The Member Secretary,
Chennai Metropolitan
Development Authority,
No.1, Gandhi Irwin Road,
CHENNAI -600 008.

Letter No.C 4/20816/2002

Dated: 27.2.2003

Sub: CMDA - Planning permission - Proposed additional
construction office building for National Institute
of Ocean technology at Velechery Tambaram Main Road,
at S.No. 657/4 part of Pallikaranai village -
Development Charges and other charges to be remitted -
Regarding

ELEVATION AT - A

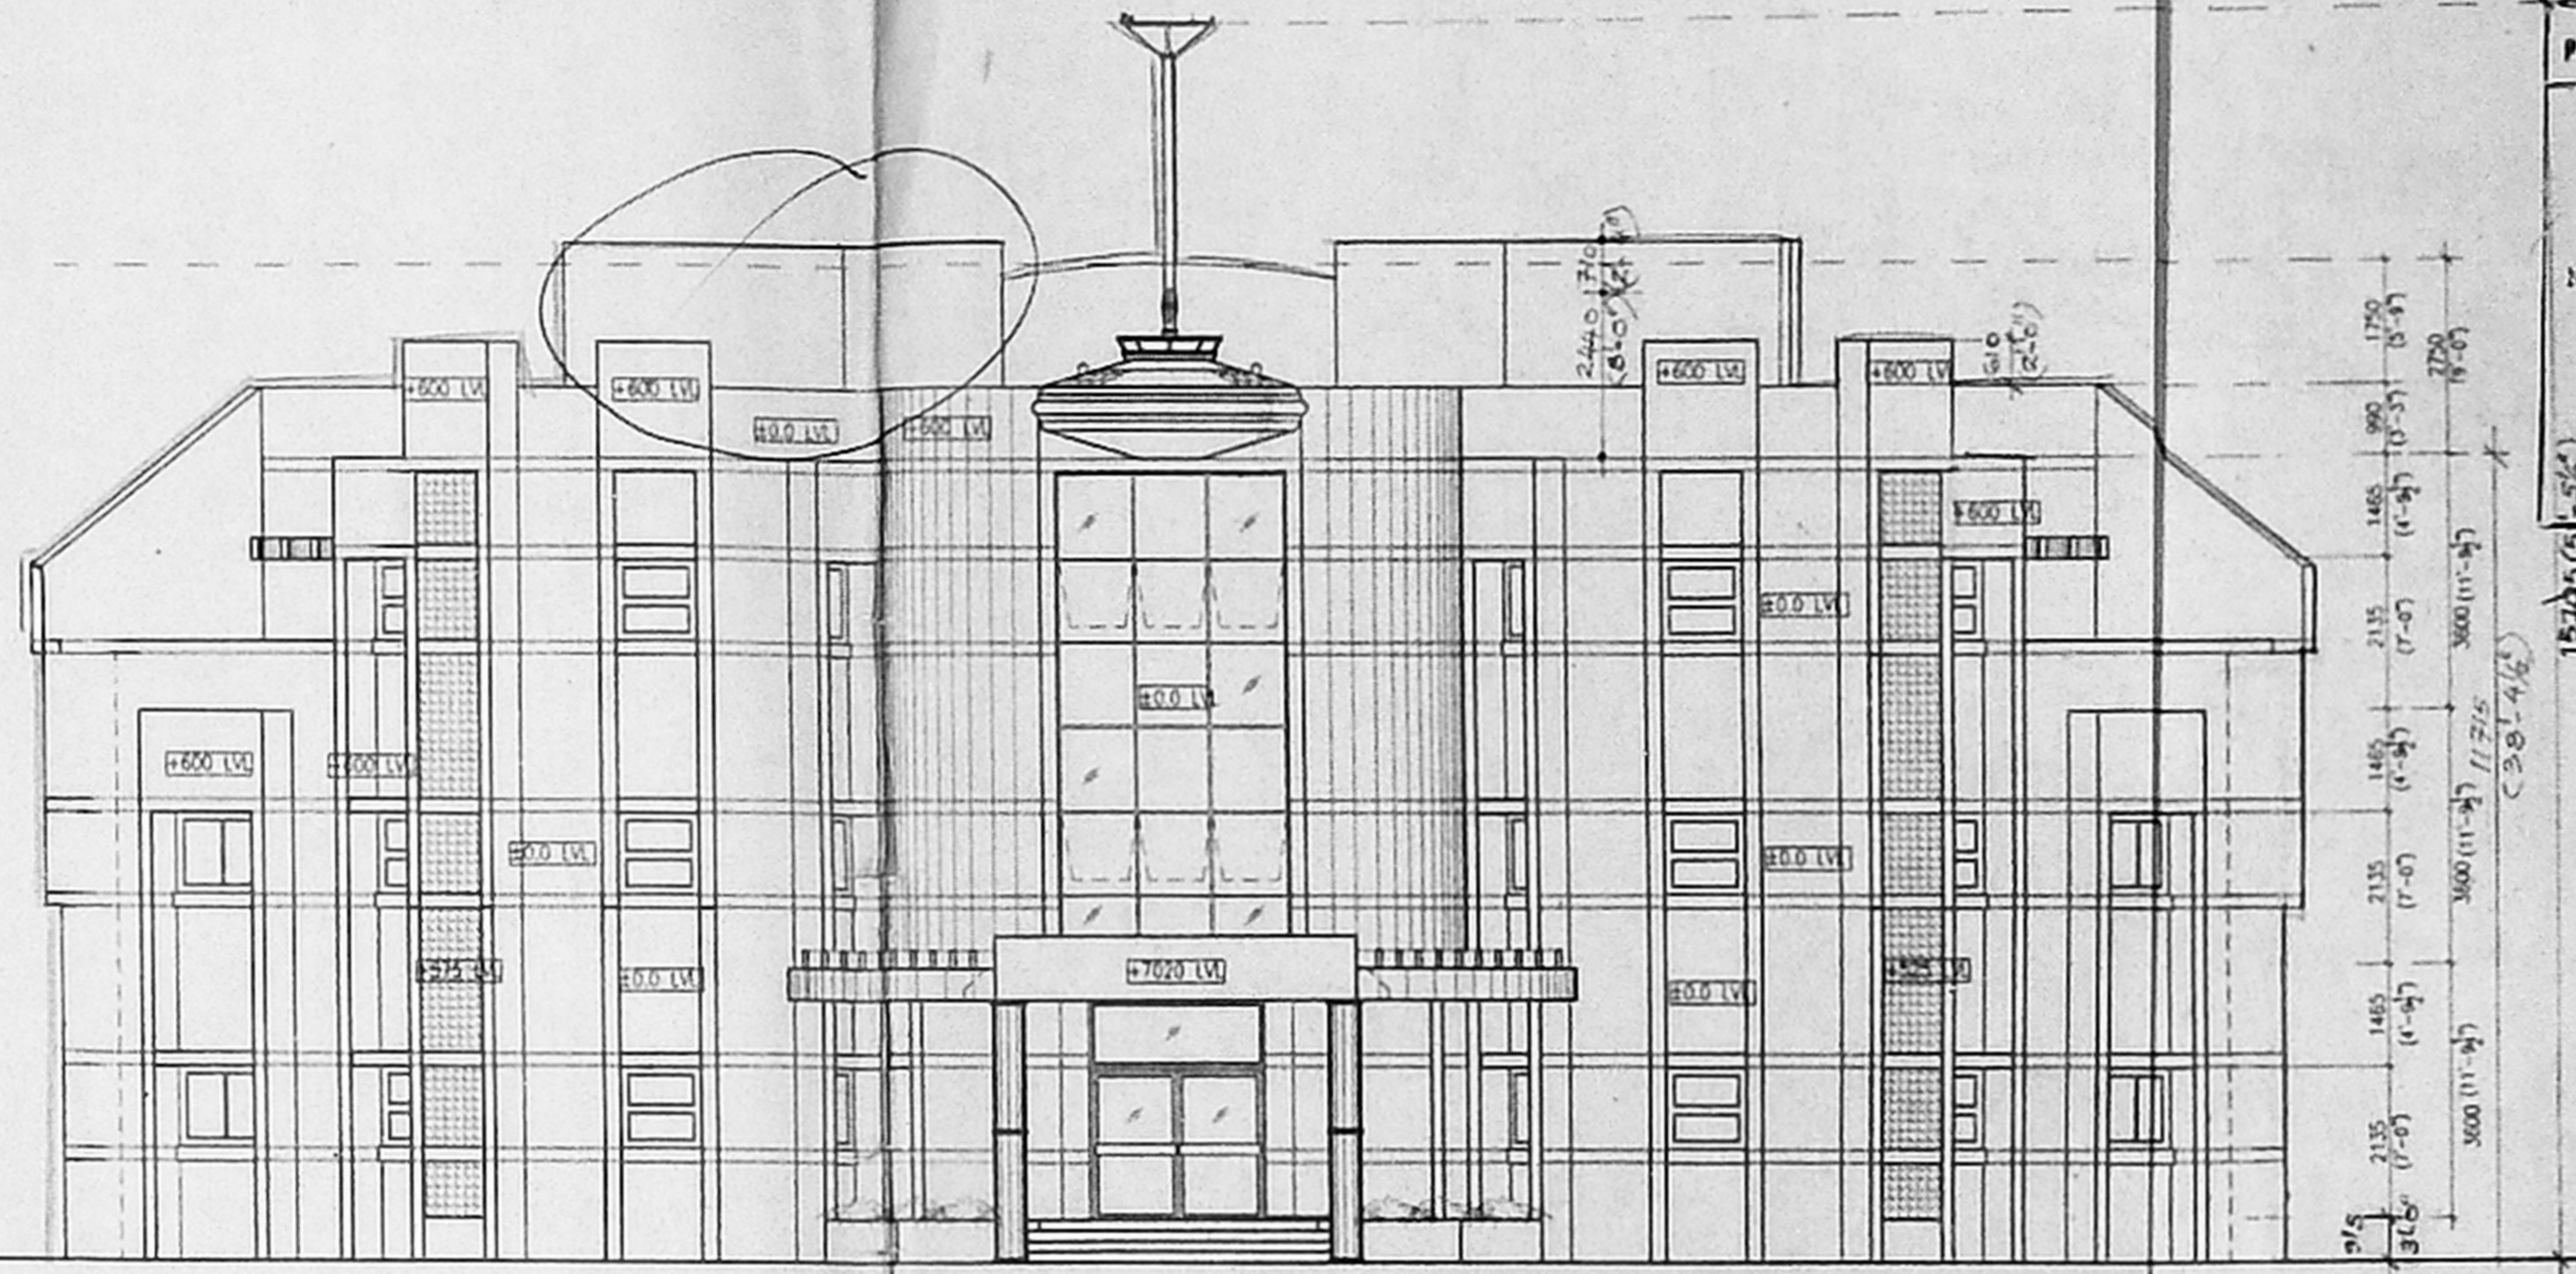
- a) Rain water conservation measures notified by CMDA should be adhered to strictly.
- b) Section on AA and Front elevation not shown correctly
- c) Height of the building not specified in the plan
- d) Height of the elevational pole in the buoy Assembly building which has not been indicated it shall be restricted to 20.00m
- e) Dwarf wall to a height of 7.5 cm height at the entrance and exit gate.
